City of Portland, Maine - Building or Use Permit Application
 389 Congress Street, 04101 Tel: (207) 874-8703, Fax: (207) 874-8716

Permit No: 05-1562	Issue Date:	CBL: 381 A006001
------------------------------	--------------------	----------------------------

Past Use: Single Family	Proposed Use: Single Family w/amendment to permit # 05-0432 for sona tube footings	Permit Fee: \$30.00	Cost of Work: \$0.00	CEO District: 5
Proposed Project Description: Amend # 05-0432 to replace frost wall with sona tube footings		FIRE DEPT: <input type="checkbox"/> Approved <input type="checkbox"/> Denied	INSPECTION: Use Group: Type	
		Signature:	Signature:	
PEDESTRIAN ACTIVITIES DISTRICT (P.A.D.)				
Action: <input type="checkbox"/> Approved <input type="checkbox"/> Approved w/Condition <input type="checkbox"/> Denied				
		Signature:	Date:

Plot Plan

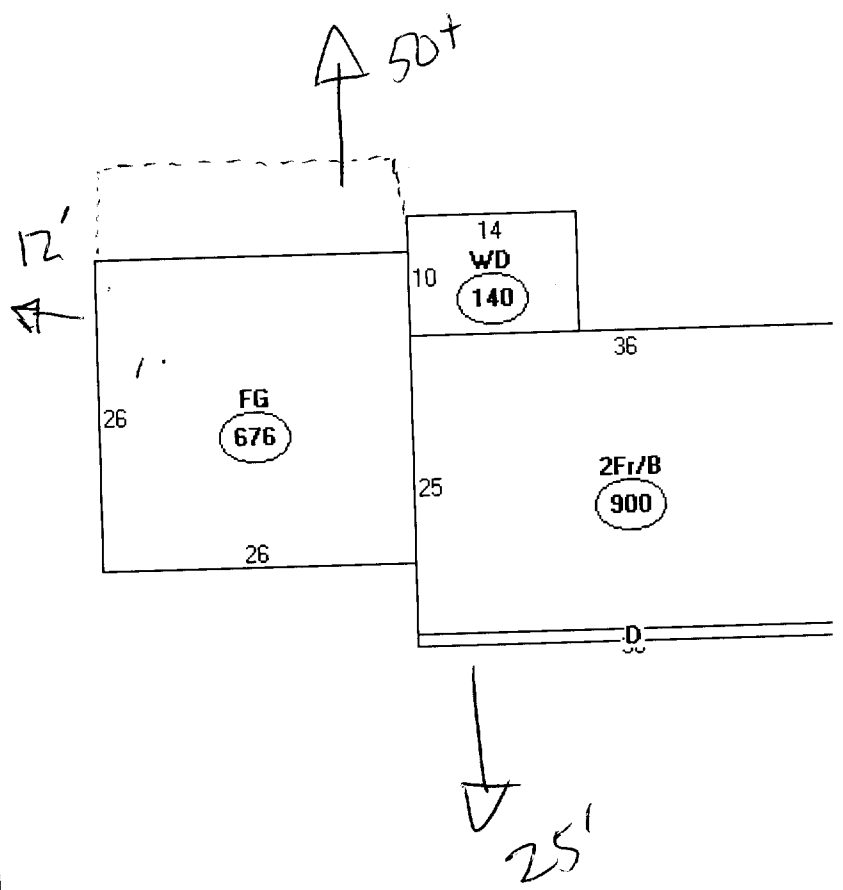
Dept: Zoning	Status: Approved	Reviewer: Jeanine Bourke	Approval Date: 11/02/2005
Note:			Ok to Issue: <input checked="" type="checkbox"/>
<p>1) Due to the lack of property monumentation, research of the original permit from 1978 shows the house & garage built to code. The zoning at that time was 10' for one story & 14' for two story. It also allowed a reduction of the side setback if increased on the other side to no less than 10'. Therefore, the 2 story house as built was reduced from 14' to 12' on the right side as the one story garage side was increased to 12'. The garage extension is not projecting any further into the side yard and based on previous records and current requirements, 12' is allowed. Inspector just verify that the existing fence is that distance, a survey is not required.</p>			
Dept: Building	Status: Approved with Conditions	Reviewer: Jeanine Bourke	Approval Date: 11/02/2005

Comments:
10/25/2005-jmb: Met w/Marge on the setback monumentation issue and existing records, agreed that the proposed garage extension meets the required 12' setback
10/26/2005-jmb: Left vm w/Al K. To call about issuing the permit
